Please ask for: Sian Eggington
Email: sian.eggington@terraquest.co.uk
Telephone: 0121 2341390
Our Ref: FP/206/20/HH
Your Ref:
Date: 29th October 2020

Application for Planning Permission for Works or Extension to a Dwelling

Development: Single storey rear extension and partial garage conversion
Location: 33 Hinde Road Felpham PO22 7QJ

Drawing P01 October 2020 Scale 1:100&1:1250 @ A3
Proposed Drawing - Ground Floor Plan, Location Plan & Elevations

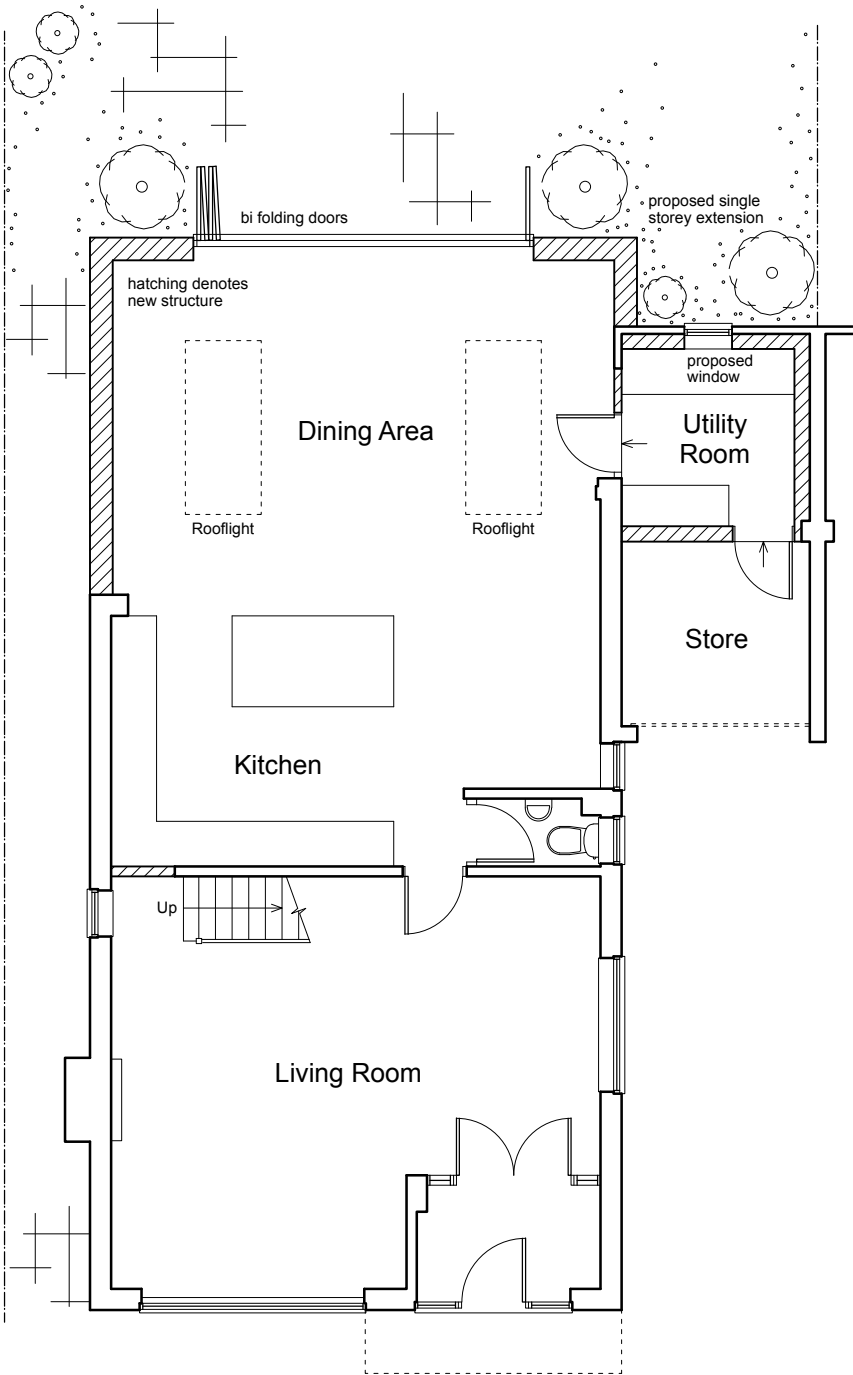
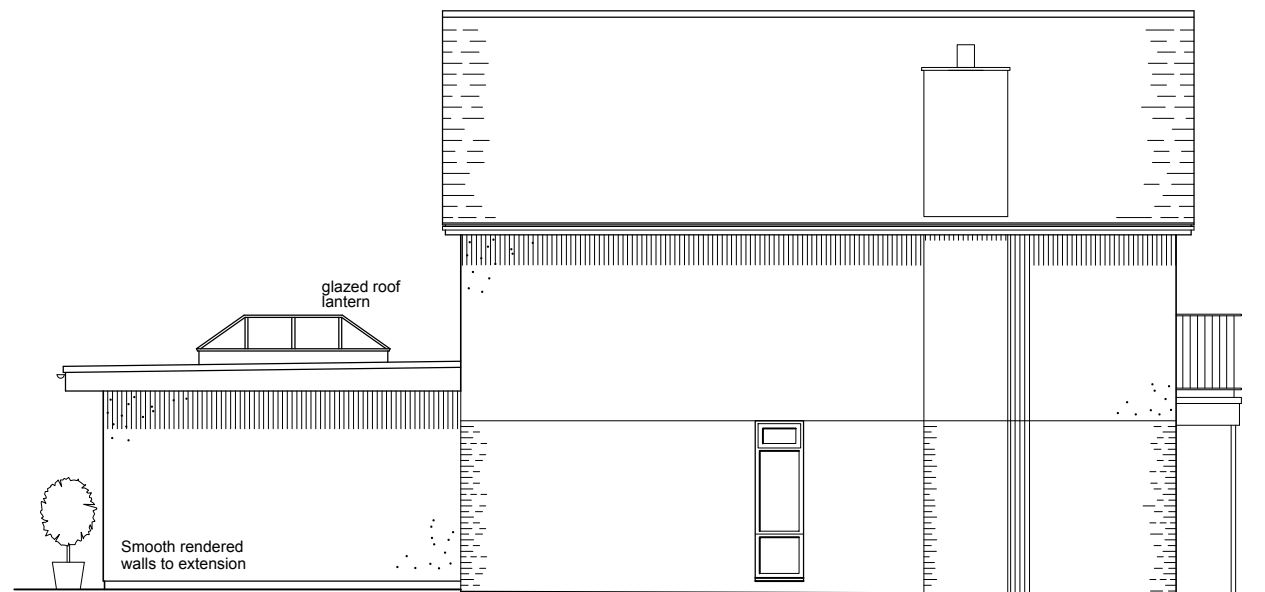
Building Line: The building line is inconsistent between the proposed floor plan and west elevation
